Our Ref: R/2017/14/R
File No: 2021/492129
Your Ref: SSD 8517 – MOD 7

Locomotive Workshop – SSD 8517 MOD 7 – Expand retail uses into Innovation Plaza – Supplementary response to submissions

2 L0 PLAN EXTRACT - INNOVATION PLAZA SOUTH
1 : 150

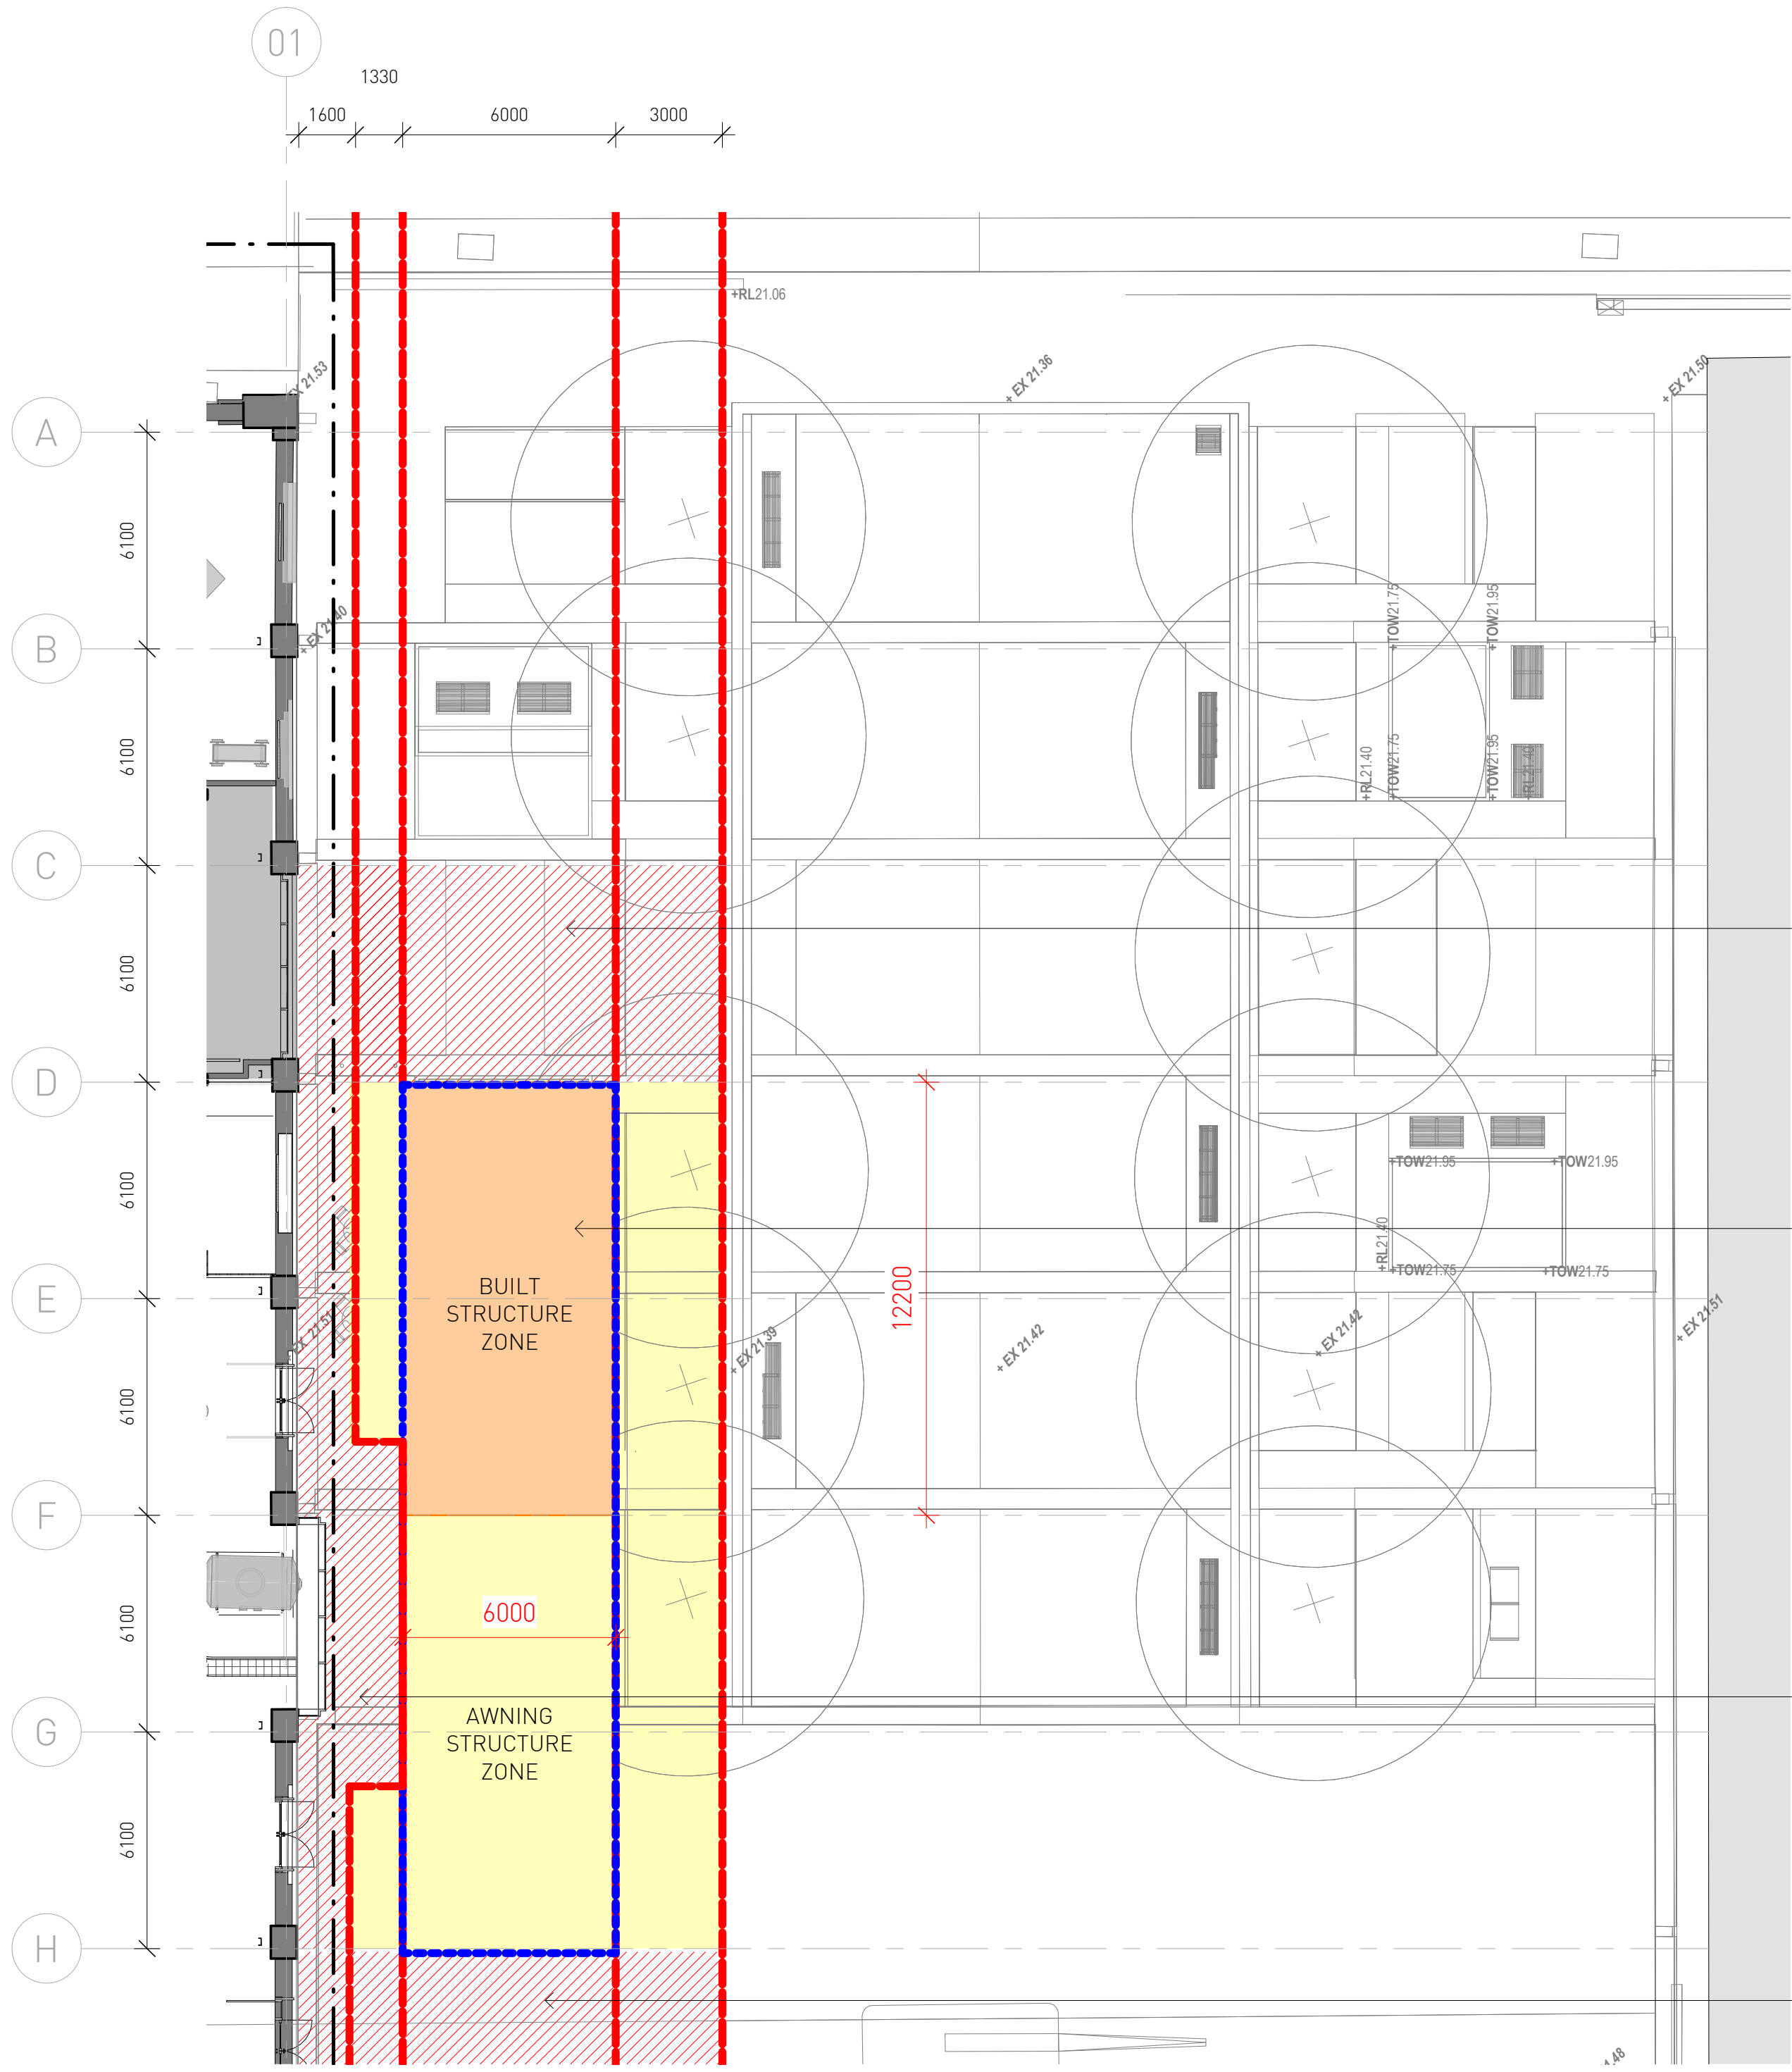
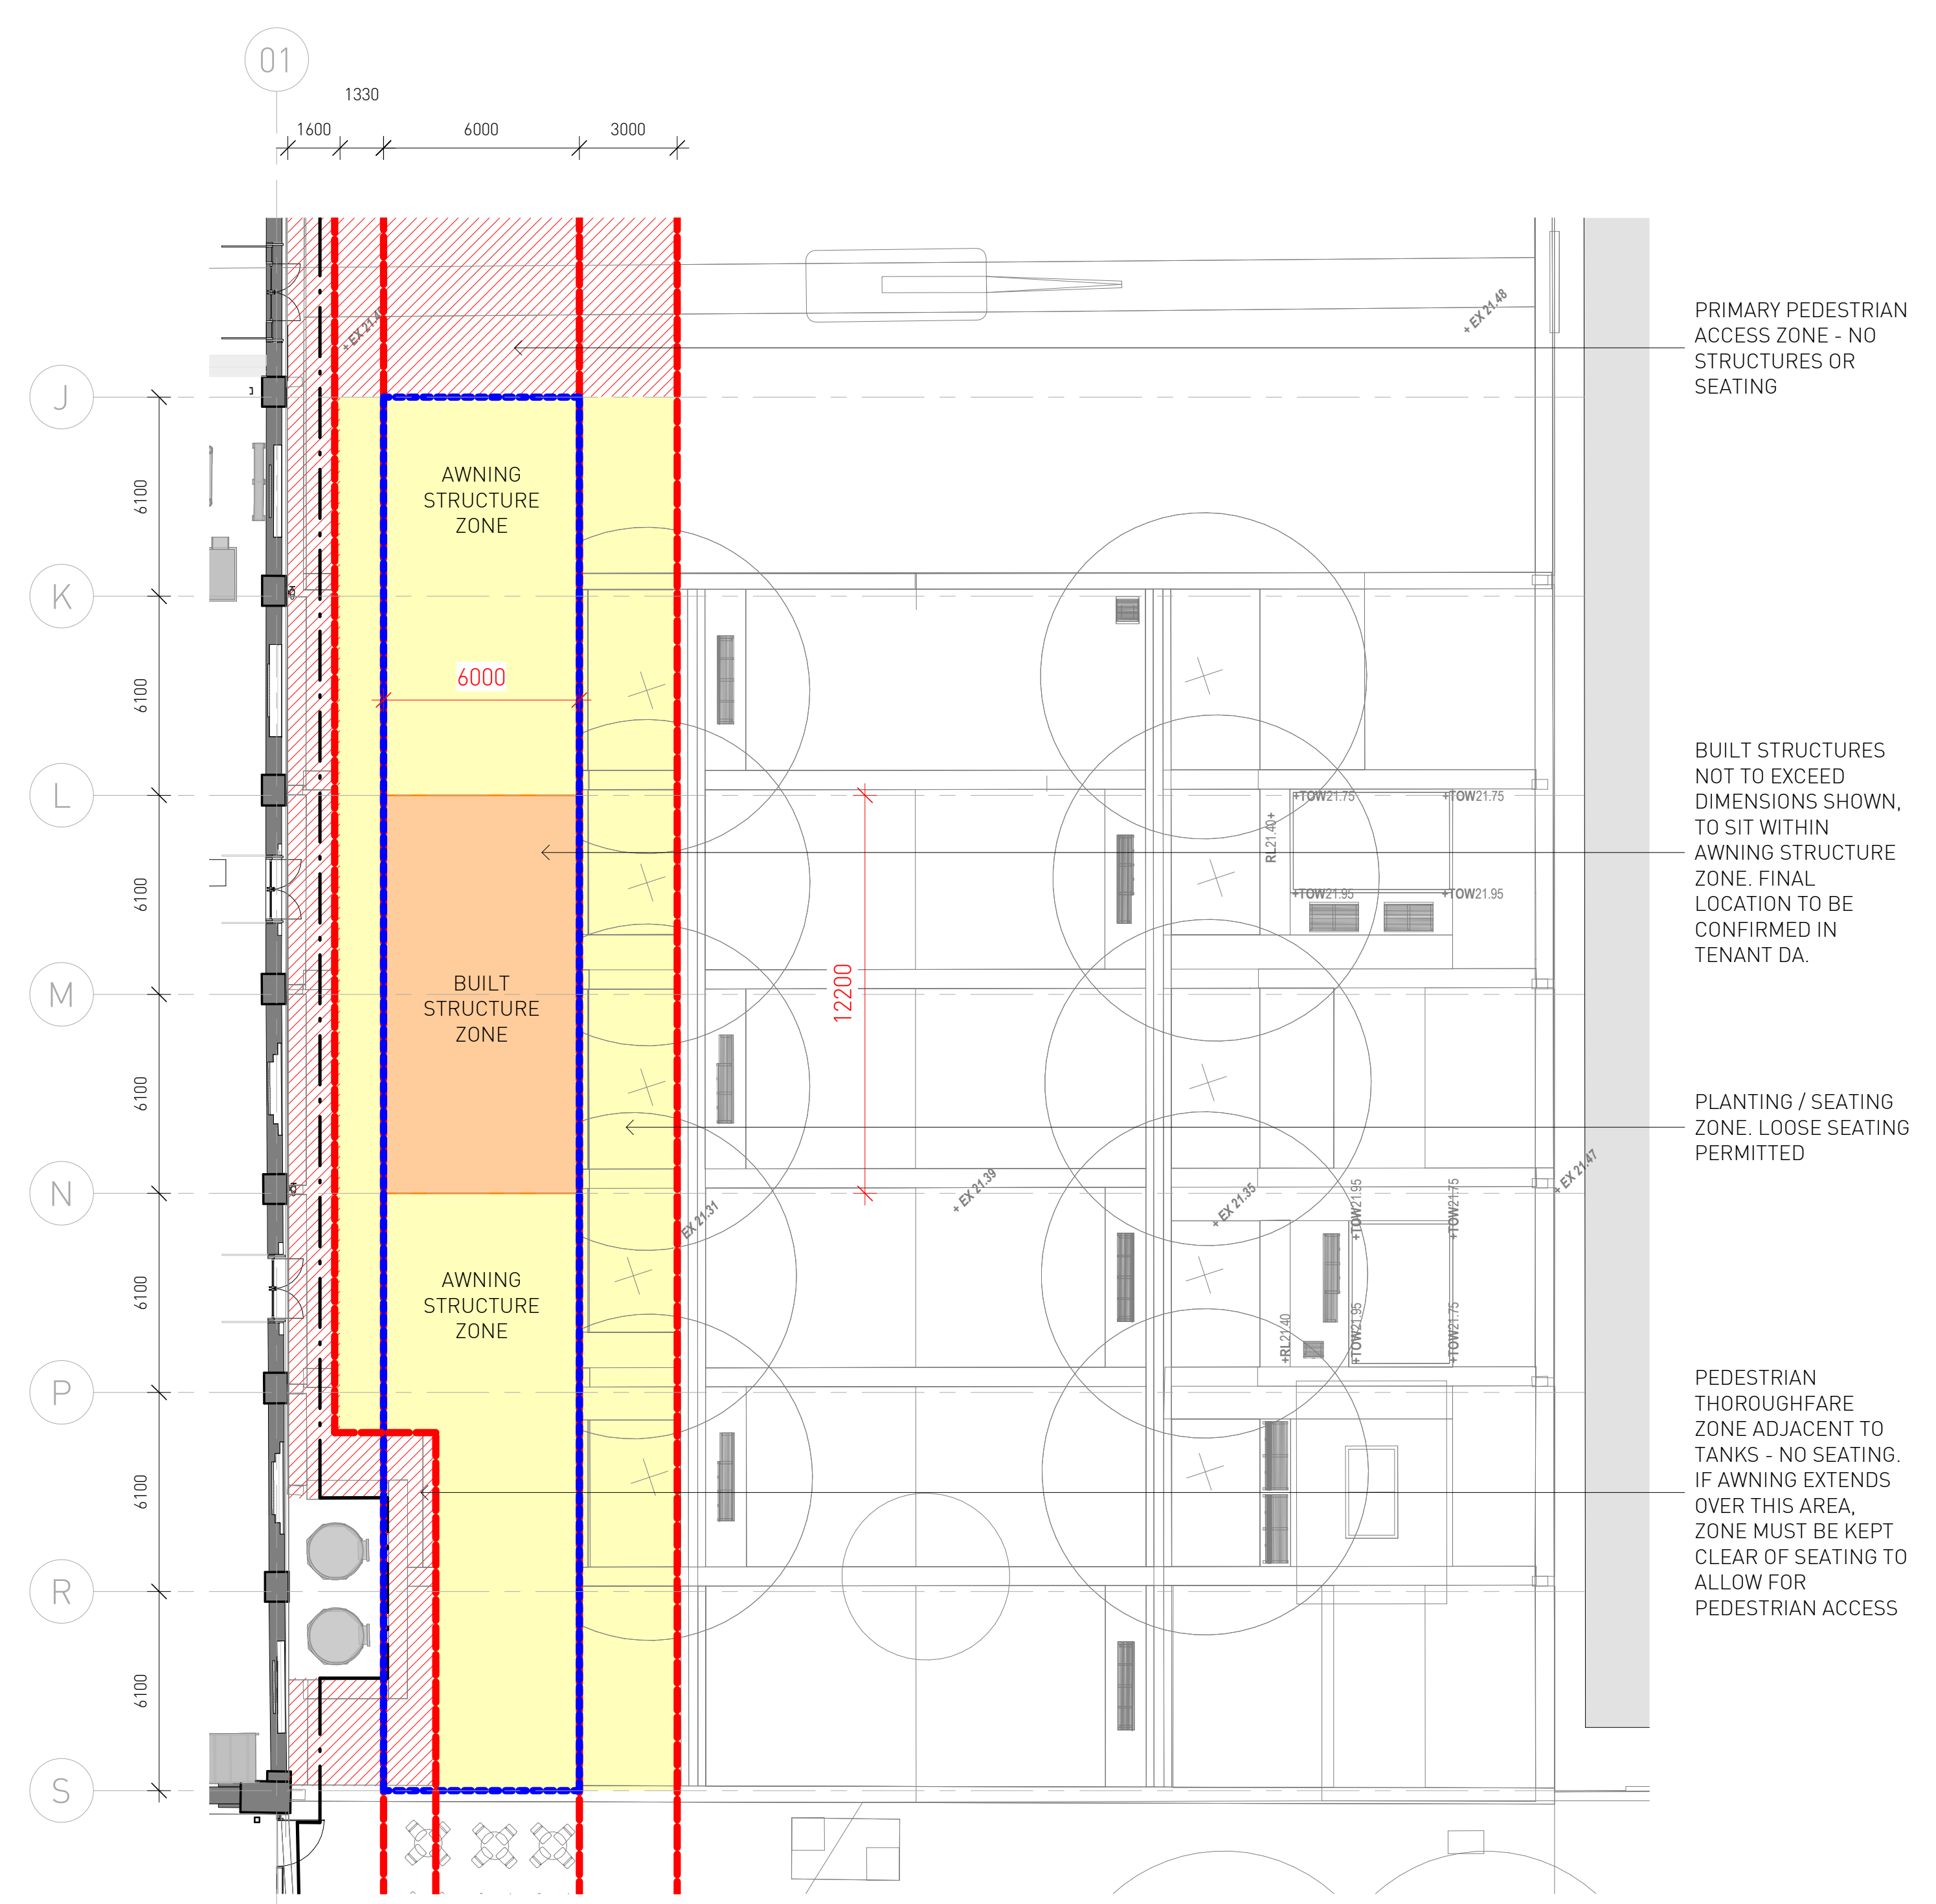
It is noted that there are still discrepancies in the architectural drawings and landscape drawings that omit the southernmost seating area in Innovation Plaza. All plans are recommended to include all details regarding outdoor seating areas. Further, outdoor seating areas are shaded in different colours in various plans with no key provided. This may result in confusion in understanding which areas are to be allocated to seating for tenants or public seating.

It is recommended that a condition of consent be imposed requiring a minimum 4.5m wide clearance to be provided between the southernmost section of seating and any other structures (including bollards) to ensure a clear path of travel is provided and appropriate pedestrian safety is maintained.
